Re: Falcon Marketplace Early Grading Permit (SP-17-001/CDR-16-007) Response 5

Please accept this response letter to your review 4 comments dated July 21, 2018.

Preliminary Drainage Report (PDR) / Drainage Plans

PROJECT NO. 20988-00CSCV  
DRAWING NO.  
**C7.3**

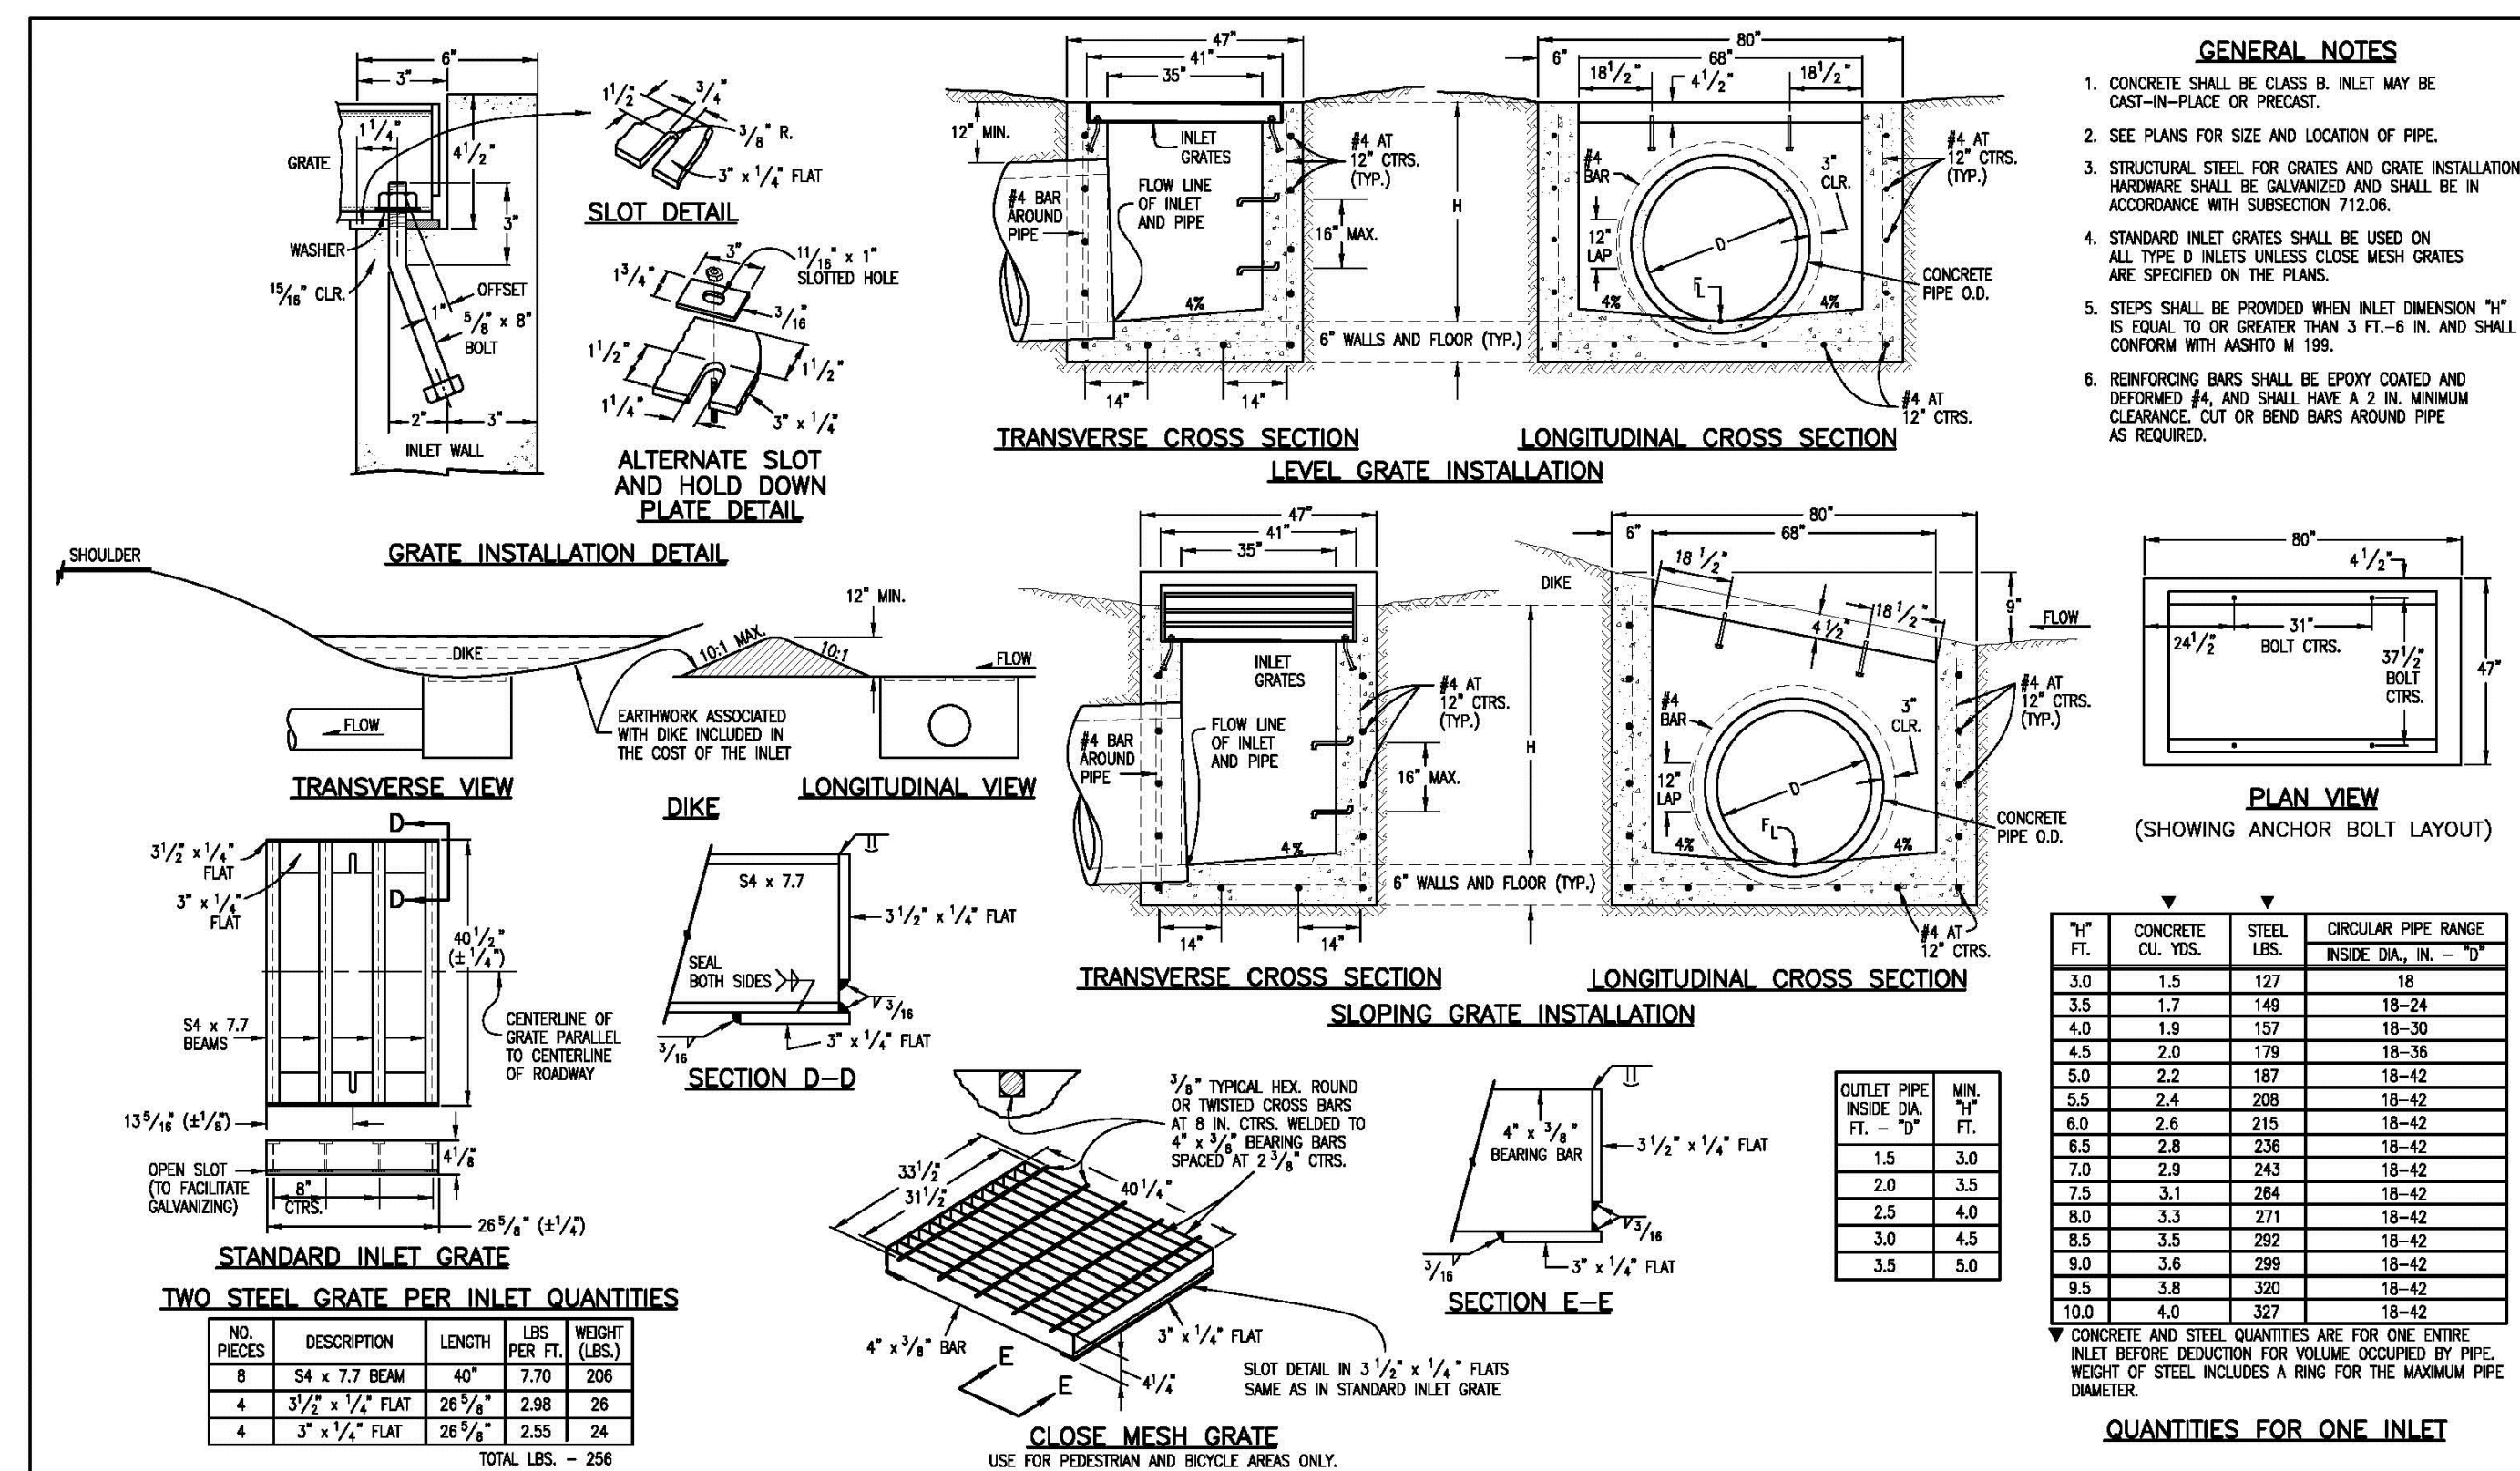
14. *Resolved*
15. *Resolved*
16. *Reference attached UDFCD outlet structure design details. Specific items that need to be incorporated into the project's outlet structure designs include the orifice plate design and notes, water quality plate details (type and thickness), stainless steel well screen (page OS-9) and neoprene gasket. Complete review of sheet C7.9 will be provided after revisions. Sheets C7.11 and C7.12 will be reviewed with the subdivision CDs. Partially resolved; see redline regarding specific calculations for trash rack (now sheet C7.5). Partially resolved; see updated redlines.*
